EPC STORMWATER REVIEW COMMENTS
 IN ORANGE BOXES WITH BLACK TEXT

EL PASO COUNTY STORMWATER MANAGEMENT PLAN CHECKLIST

EPC Project Number: 36

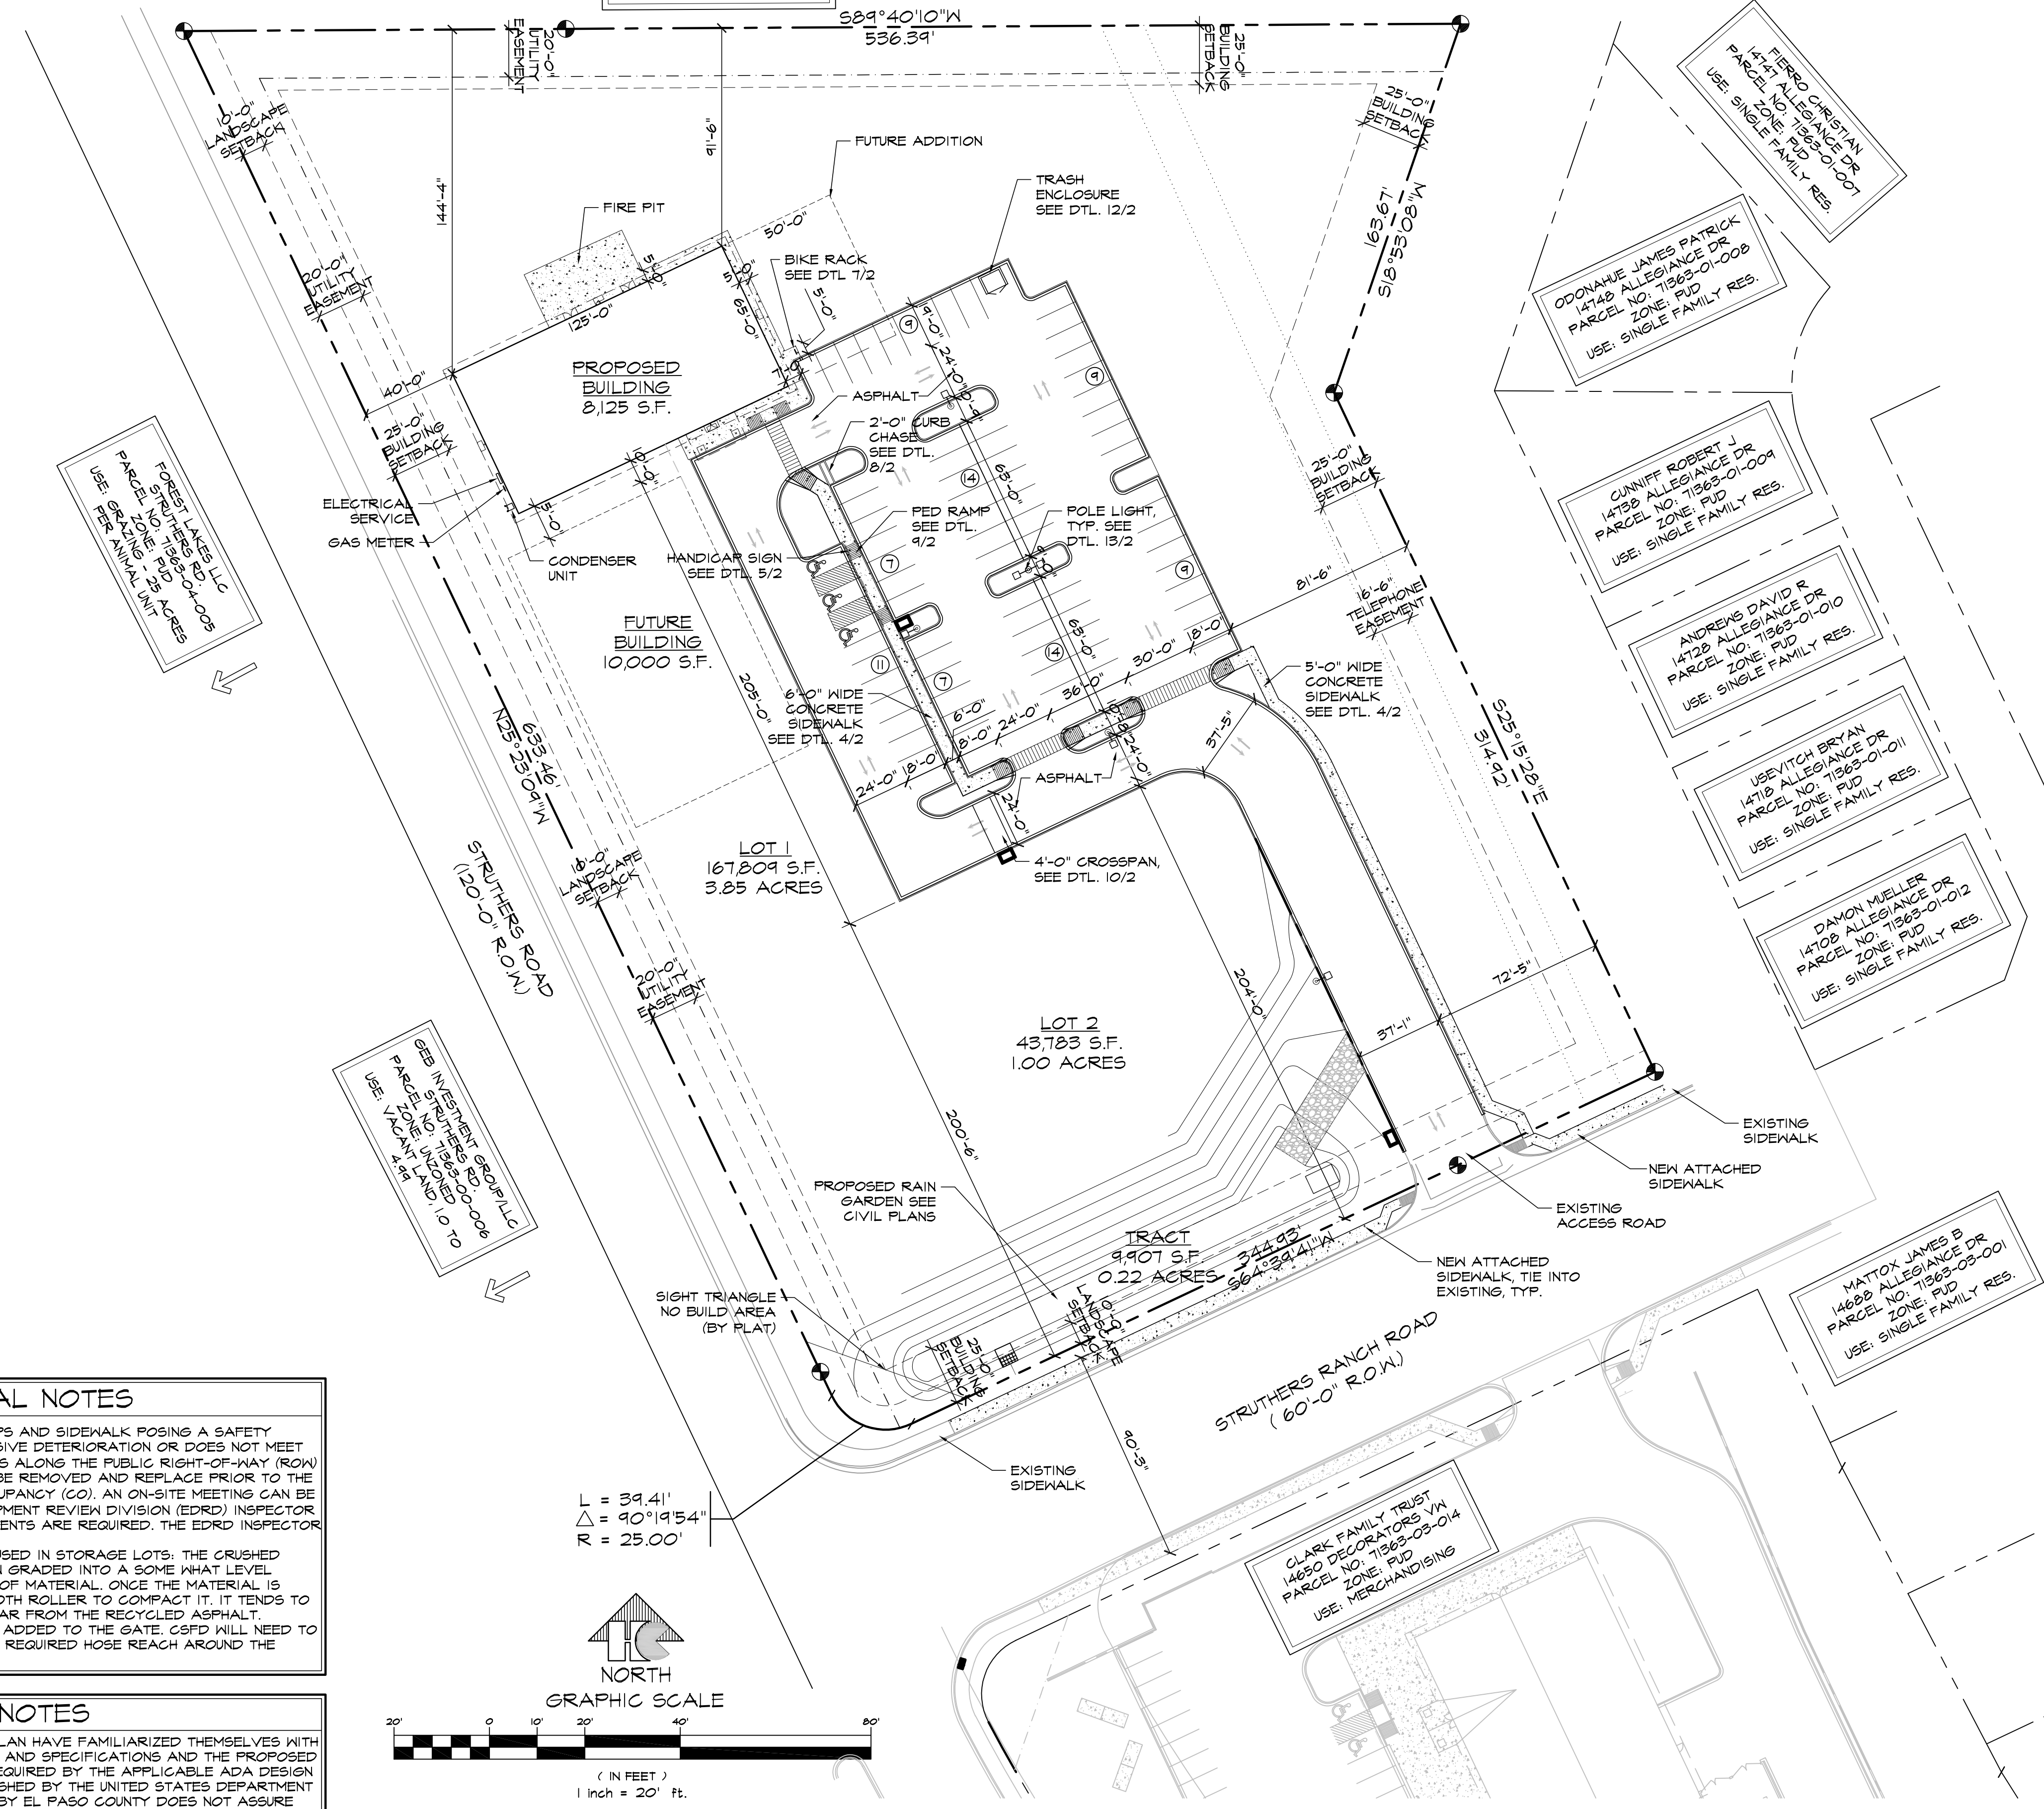
Applicant	EPC
17	SWMP Map to include:		
17a	construction site boundaries		Y
17b	flow arrows to depict stormwater flow directions		N
17c	all areas of disturbance		Y
17d	areas of cut and fill		Y
17e	areas used for storage of building materials, soils (stockpiles) or wastes		Y
17f	location of any dedicated asphalt / concrete batch plants		N
17g	location of all structural control measures		Y
17h	location of all non-structural control measures		Y
17i	springs, streams, wetlands and other surface waters, including areas that require maintenance of pre-existing vegetation within 50 feet of a receiving water		Y
18	Narrative description of all structural control measures to be used. Modifications to EPC standard control measures must meet or exceed County-approved details		Y
19	Description of all non-structural control measures to be used including seeding, mulching, protection of existing vegetation, site watering, sod placement, etc.		Y
